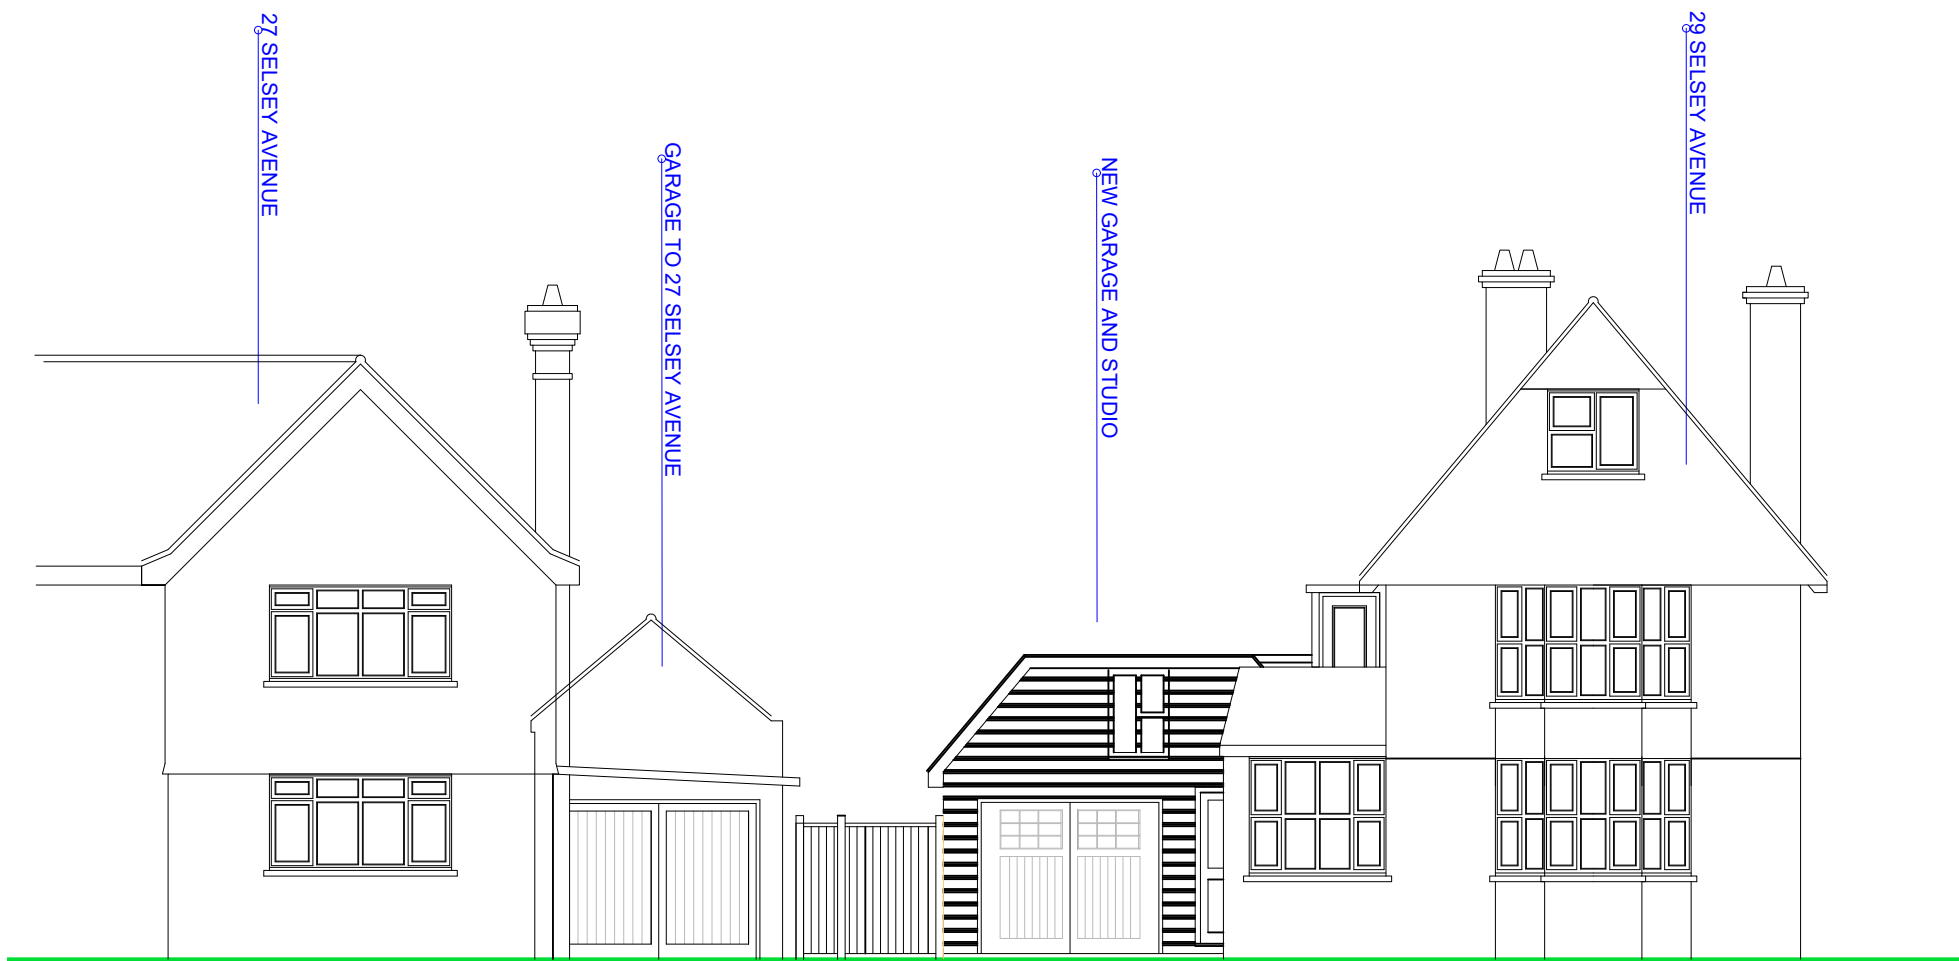
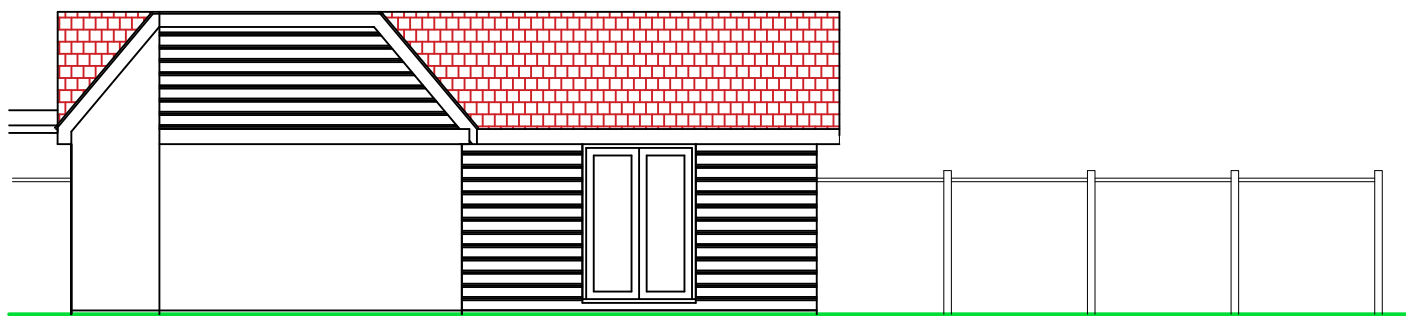
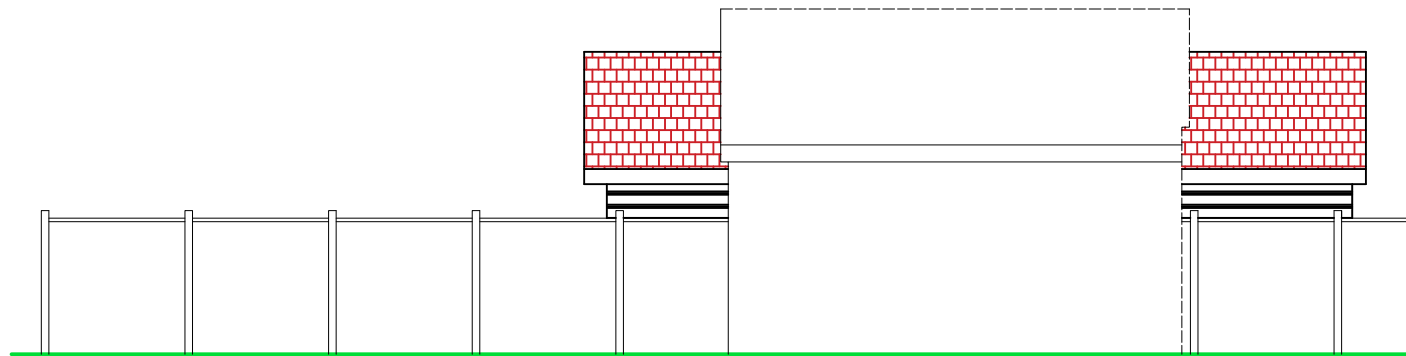
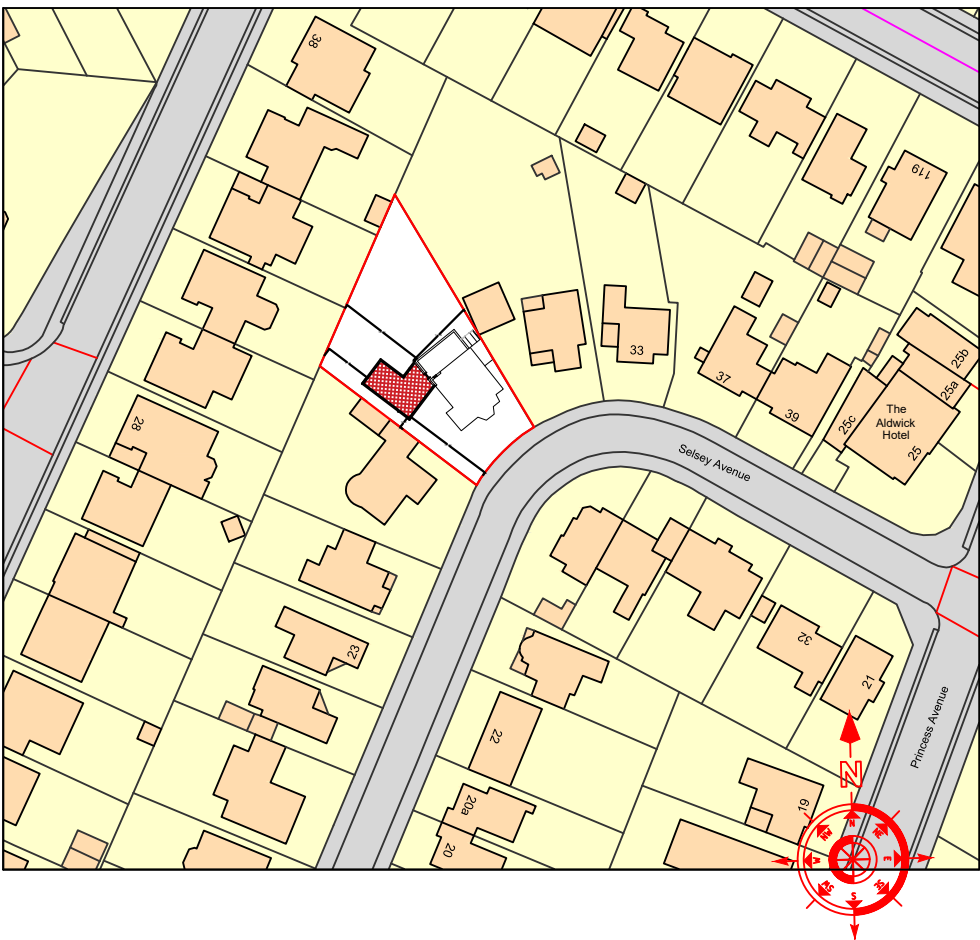
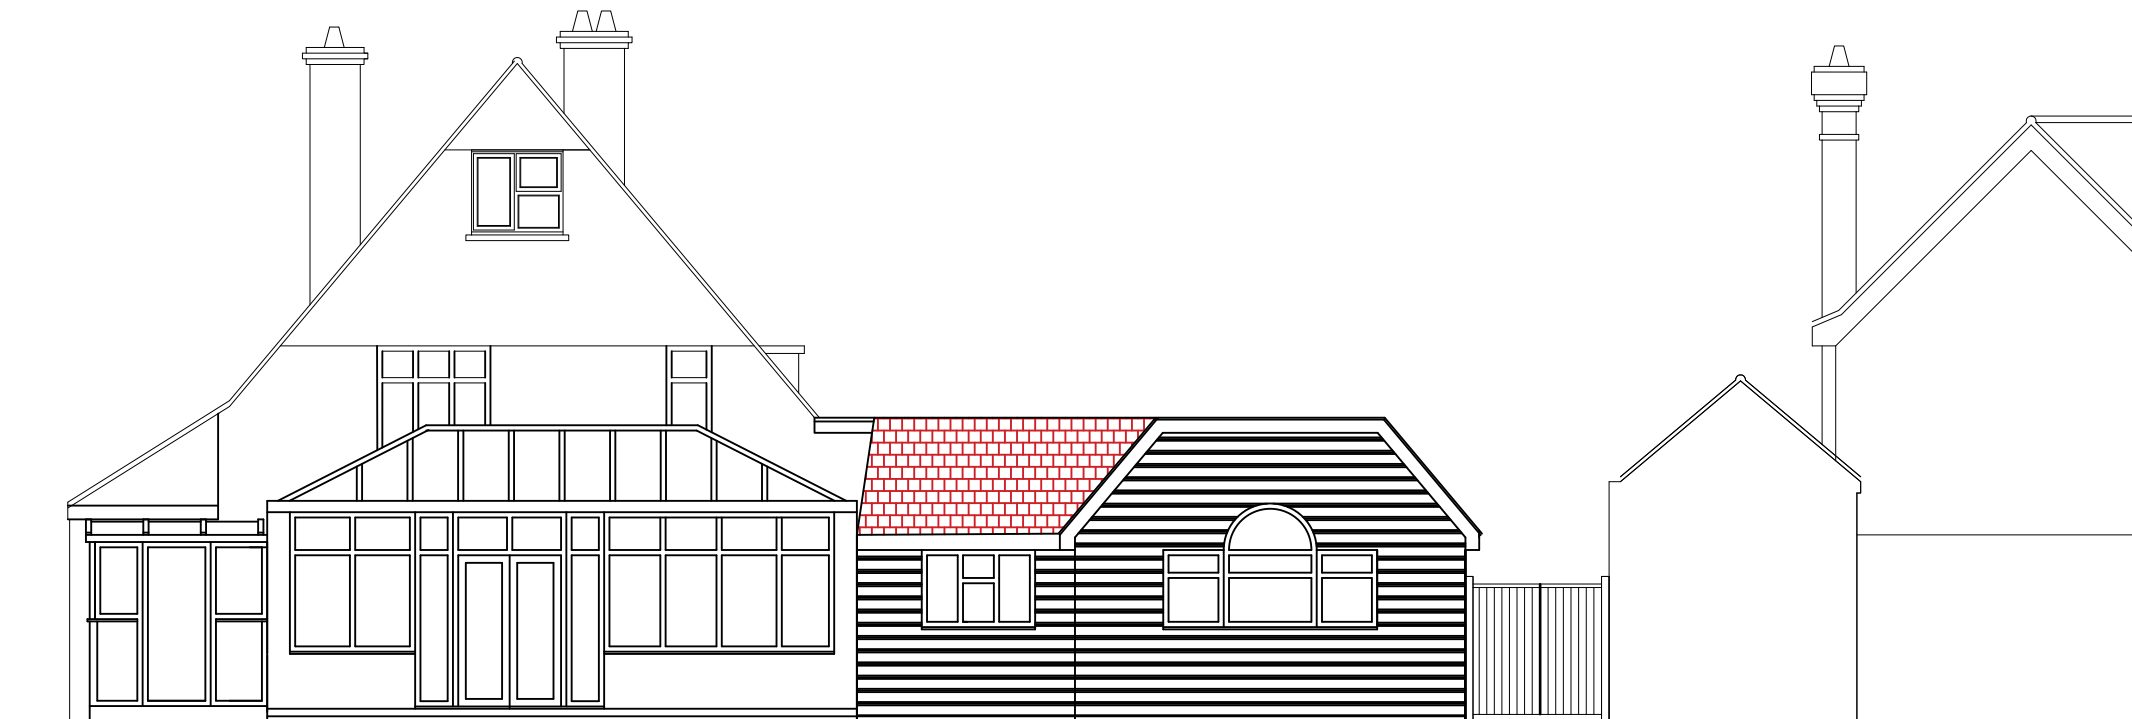
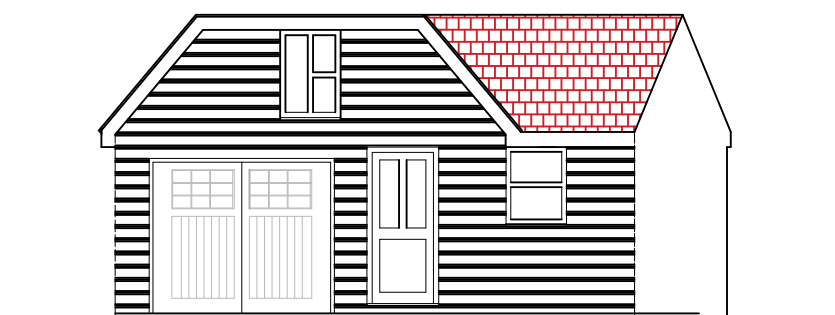
Elevations: Please provide the existing elevations.

Block plan 1 : 500

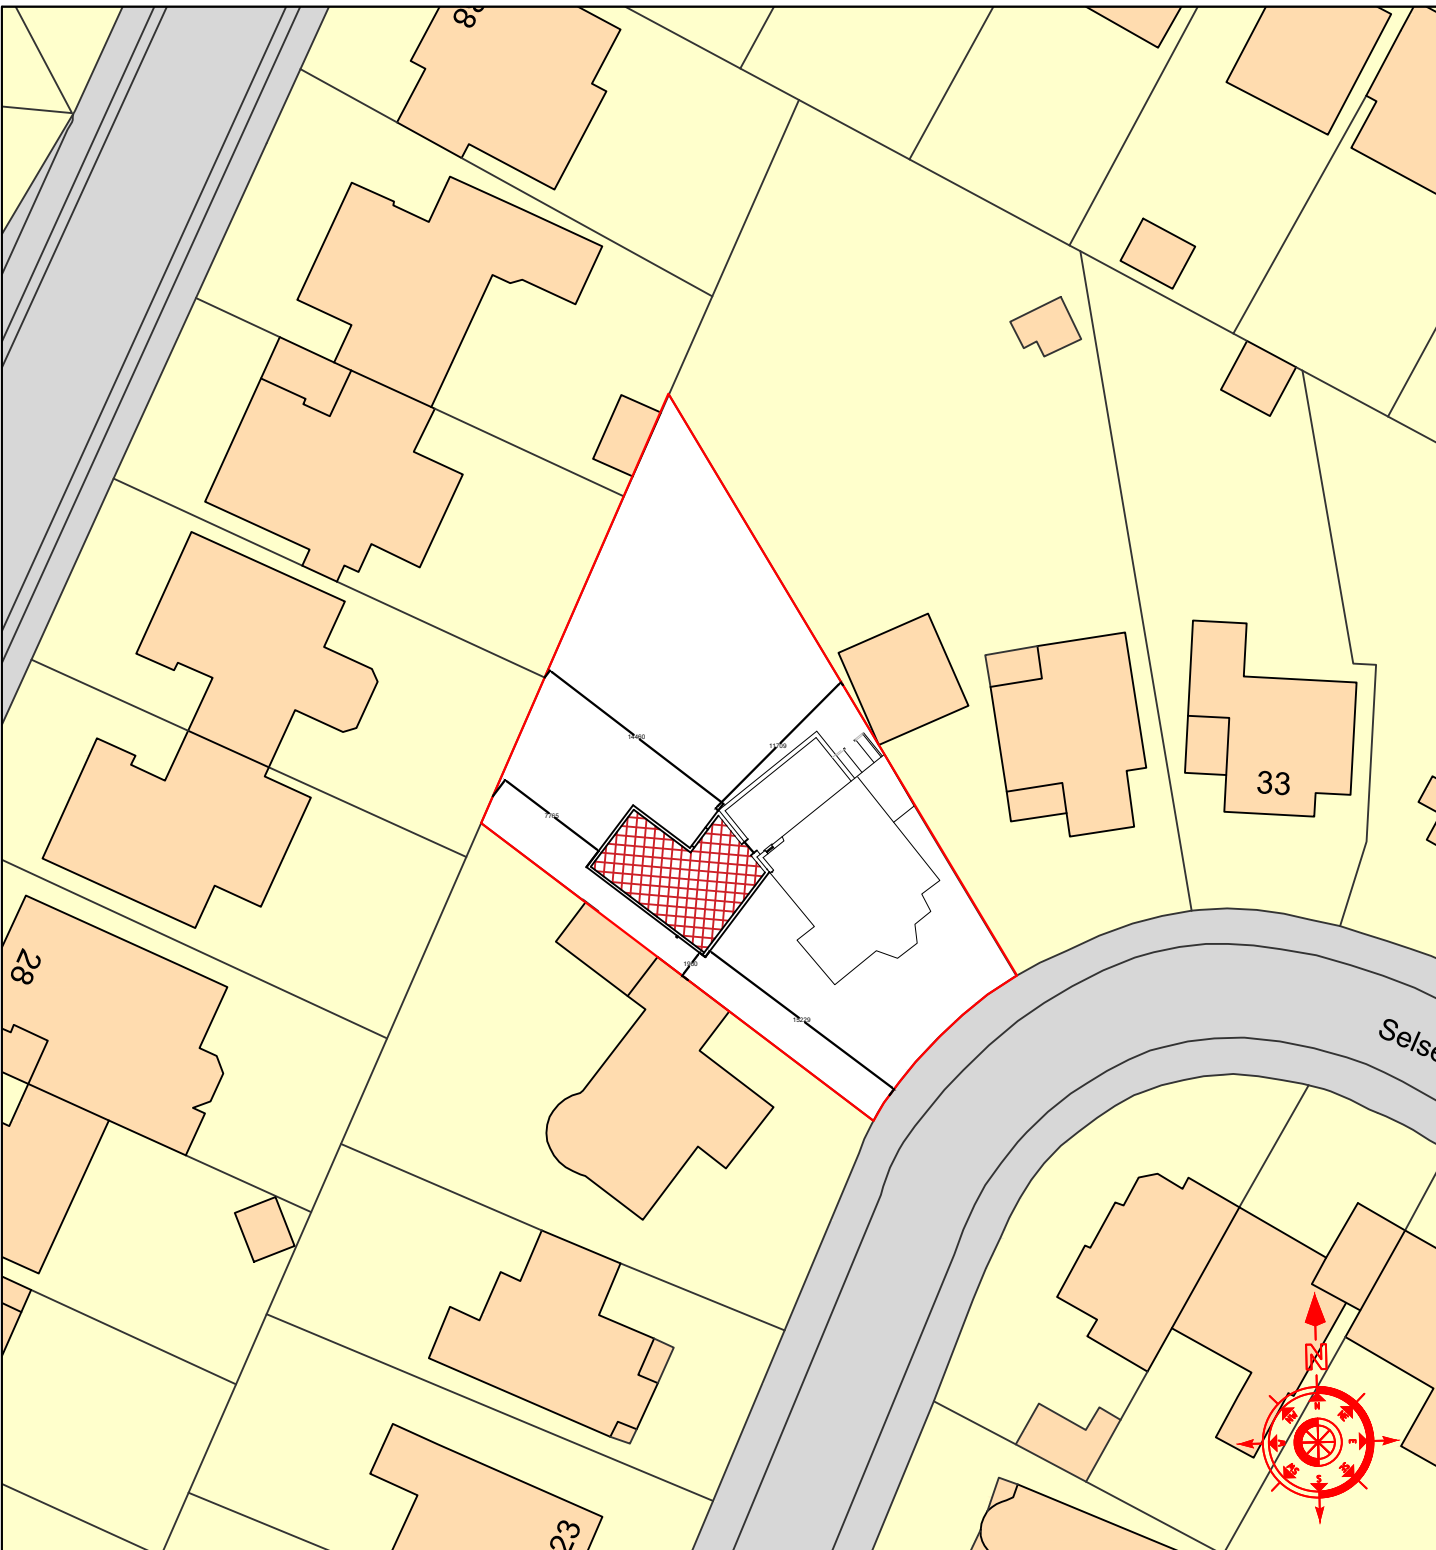
Block Plan: Please add the dimensions from the proposed works to the front and other side boundary.
